Subject: RE: EP/39/22/PL 29 Tamarisk Way

This application is being taken to committee because of objections from the Parish. It is going to August's meeting. We are recommending it for approval on the basis it would be PD.

Apologies for the delayed response relating to the above application which was recently transferred over to me. Having now looked through the application documentation and recent correspondence with Obafemi and having had the chance to discuss the case with Juan, we feel that the loss of the eyebrow dormers would have a detrimental impact to the character of the building.

Figure 2 - Proposed Northern Elevation

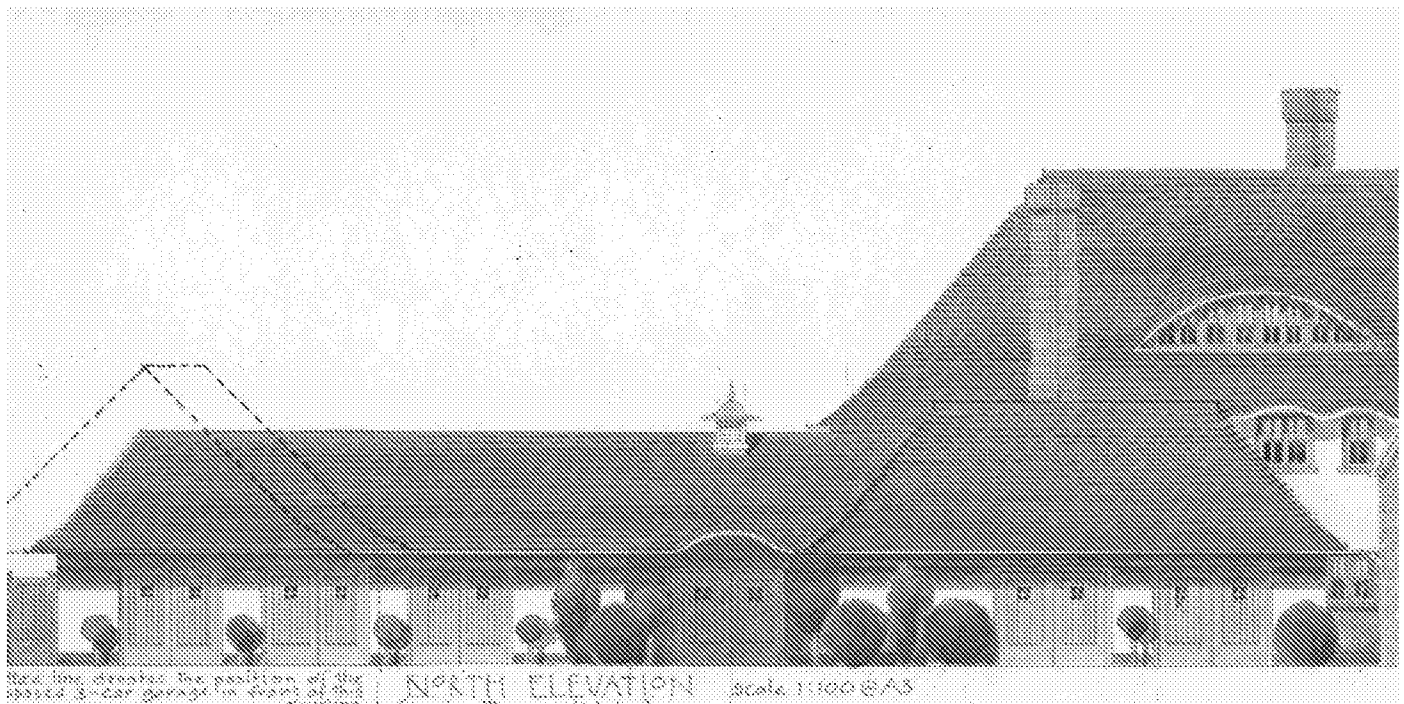
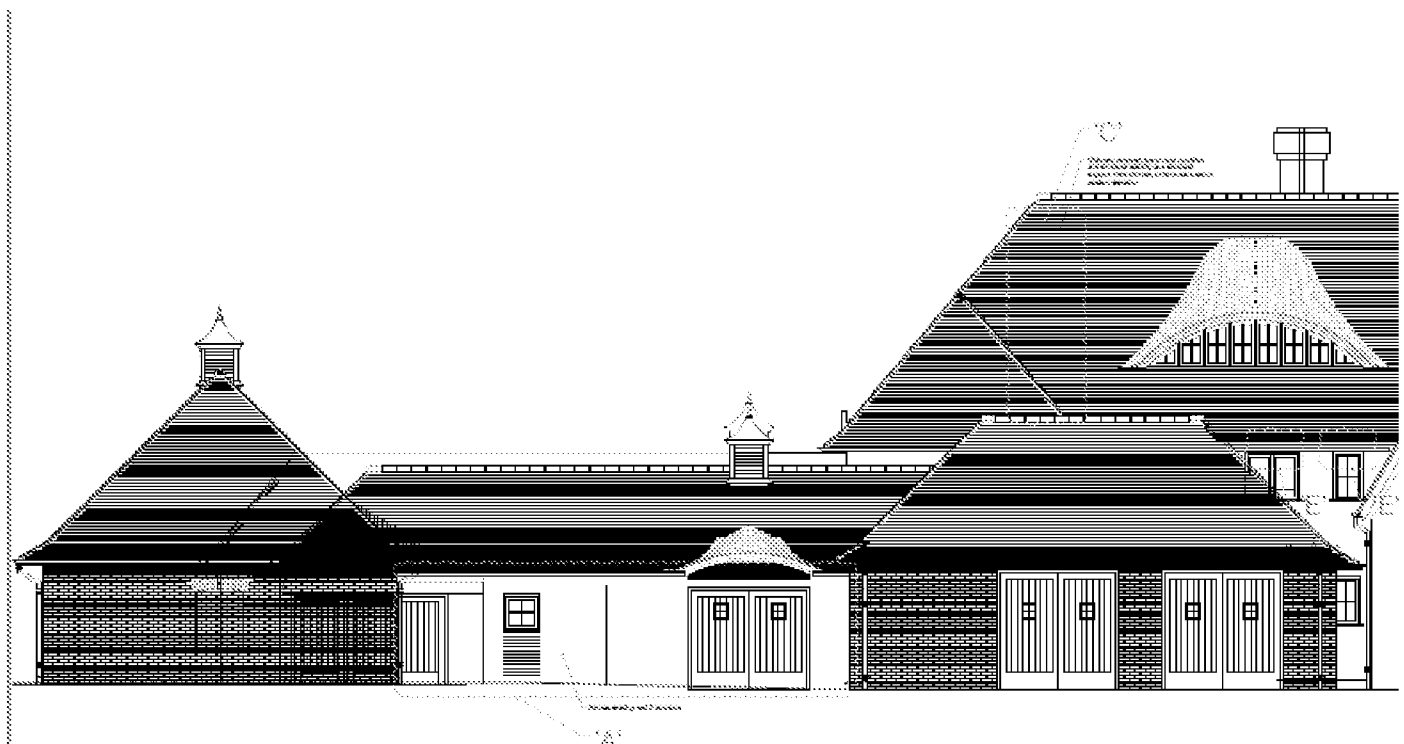
As a Locally Listed Building any alterations are expected to relate sensitively and respect the architectural interest as per Policy HER DM2 of the ALP. As stated above the eyebrow windows form part of the character and as such we seek to preserve these features of interest. I understand that there are difficulties relating to the rainwater gear however, technical matters of design are not a concern for planning, and we would request you seek an alternative method to install the guttering whilst maintaining the special architectural features of the building.

The aspects which we believe you to be referring to are those sections above the windows, identified as 'E' on the proposed plans. Please could you confirm? If so then, as you have acknowledged, we would not be able to provide these design features due to the proposed rain water guttering. This has been explored and unfortunately there is not another method available in providing the guttering without detriment to the visual impact of the building which is considered to be more significant than the loss of the design features to these windows. We would therefore suggest that there is not an alternative method to install the guttering.

The browed eaves were not structural and were part of the thatch roof which the original consent gained permission to remove. The browed eaves are not supported by timber substructure and we therefore cannot replicate such minor protrusions within the tiled roof.

Although the proposed plans seek to remove the browed eaves above the windows, the scheme seeks to retain the eyebrow dormers as previously approved at roof height and ground floor. The eyebrow dormers are considered to be the special architectural features of the building which are capable of being delivered. Unfortunately it is not possible to deliver the browed eaves as part of the tiled roof. This was only possible with the thatch roof.
